Our ref: NO/2023/115615/01-L01
Your ref: 3/2023/0814
Date: 10 November 2023

**PROPOSED SINGLE-STOREY EXTENSION TO REAR AND SINGLE-STOREY
EXTENSION TO SIDE. CONVERSION OF EXISTING BARN INTO ANCILLARY
LIVING ACCOMMODATION AND CREATION OF REAR BALCONY. EXTENSION OF
EXISTING GARAGE TO INCORPORATE ADDITIONAL PARKING BAY.
SPRINGWOOD WHALLEY ROAD, HURST GREEN, BB7 2NP**

Environment Agency position

Project Name	Project No.	Stage
Springwood	175.23	Planning Submission
Proposed Site Plan - Ground Floor	Scale	1:100 @ A1
09	Date	September 2023
Rev B	Drawn	RH

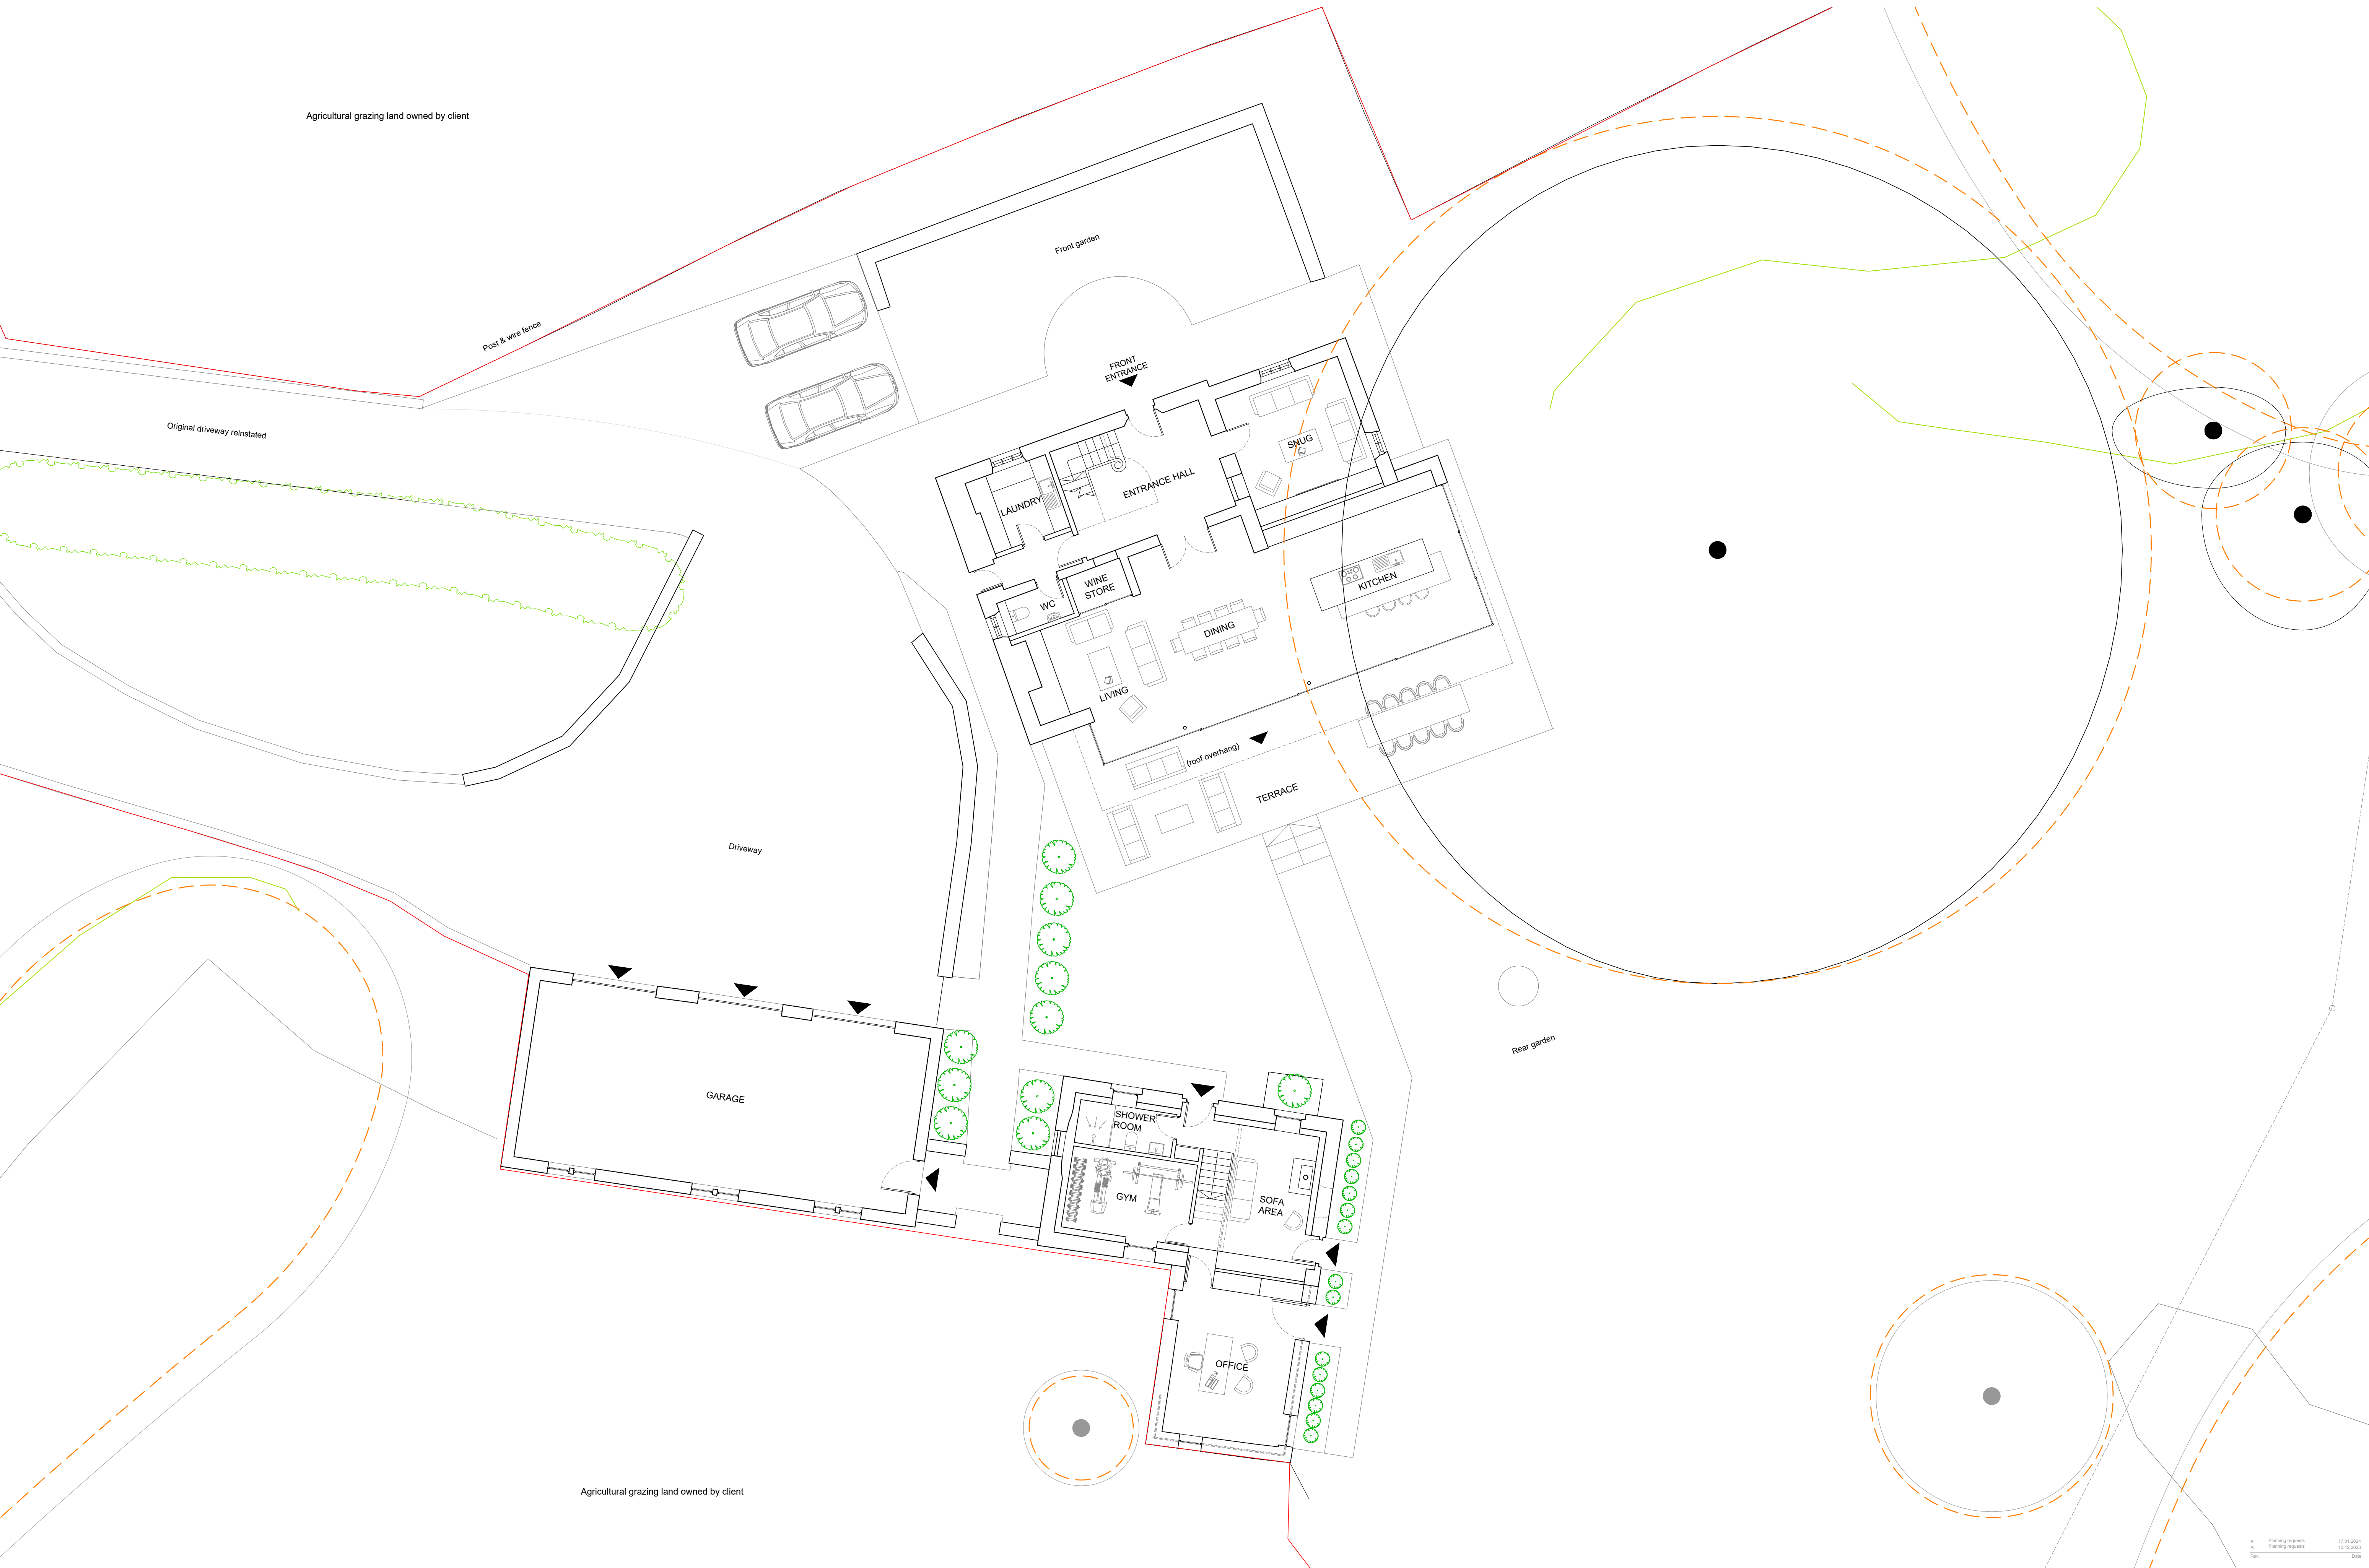
The red-edge boundary of the planning application includes an area that is located within Flood Zone 3, which is land defined by the planning practice guidance as having a high probability of flooding. The National Planning Policy Framework (paragraph 167, footnote 55) states that an FRA must be submitted when development is proposed in such locations. This application is not accompanied by a Flood Risk Assessment.

While the application boundary falls within Flood Zone 3, the proposed development is wholly within Flood Zone 1, with the exception of a small portion of the extension to the barn which may fall within Flood Zone 2, which represents the potential future flood zone, therefore all built development is on land defined as having a low probability of flooding. As no development is proposed within Flood Zone 3, there are no tidal or fluvial flood risks that we would expect to be considered through a FRA.

The site boundary runs alongside the River Hodder, which is a designated Main River. All built development appears to be over 30metres from the top of the bank of the River Hodder however, we take this opportunity to remind the applicant of the rules governing

The risk of flooding from other sources has not been considered. It will be for the Local Planning Authority to decide whether or not the application should be supported by a FRA to consider the risk of flooding from other sources in this instance.
